From: Iqraa Malik <[REDACTED]> on behalf of Terraquest
<[REDACTED]>
Sent: 23 July 2026 13:14
To: Iqraa Malik
Subject: FW: Ref R/103/26/HH
Attachments: 001_Location Plan.pdf; 002_Block Plan.pdf; 003_Existing Site Plan.pdf; 004_Proposed Site Plan.pdf; Biodiversity Enhancement Statement.pdf

From: Paul Kimber <[REDACTED]>
Sent: 22 July 2026 16:48
To: Planning.Responses <[REDACTED]>
Cc: Dan Kimber <[REDACTED]>
Subject: Ref R/103/26/HH

The reference number you provided is R/103/26/HH.

In response to the amendments, I agree to the change of application description to 'Replacement garden shed within the rear garden'

LOCATION PLAN
Rear garden project
1:1250 at A2

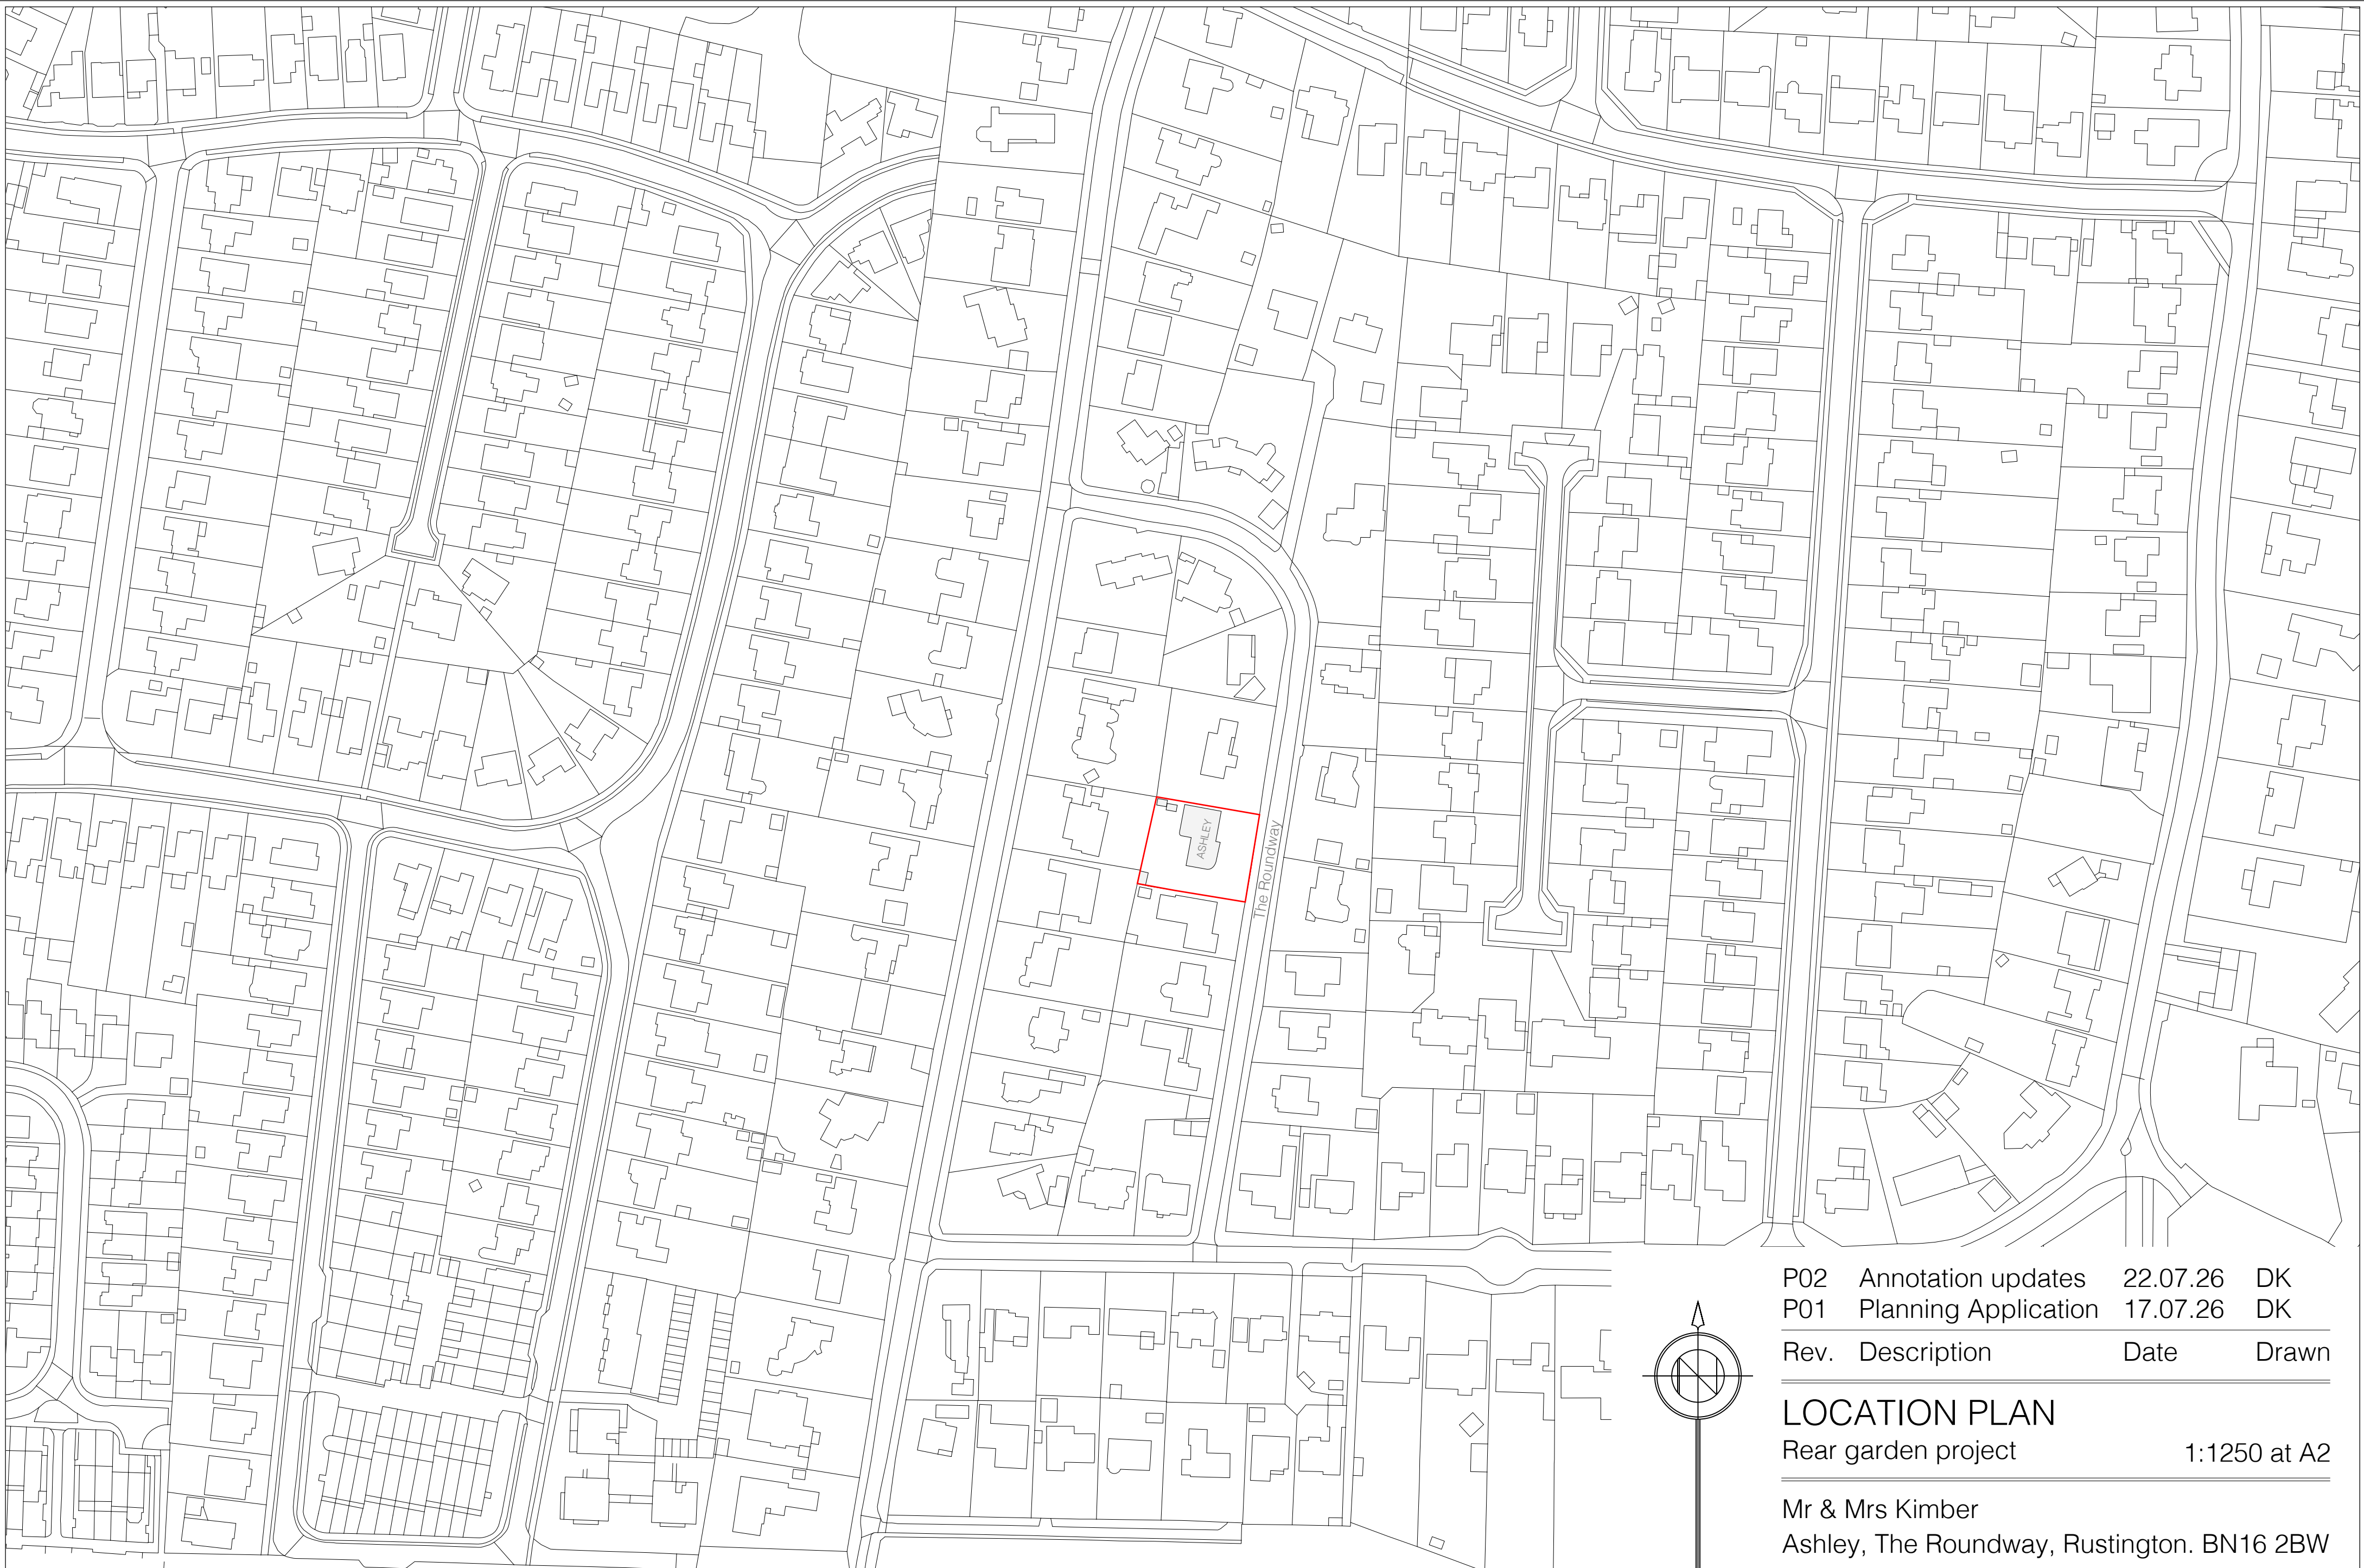
- Consistent shed dimensions across all drawings.
- Solid red line site boundary.
- Inclusion of scale bars.
- Addition of suggested dimensions relating to proximity to site boundary
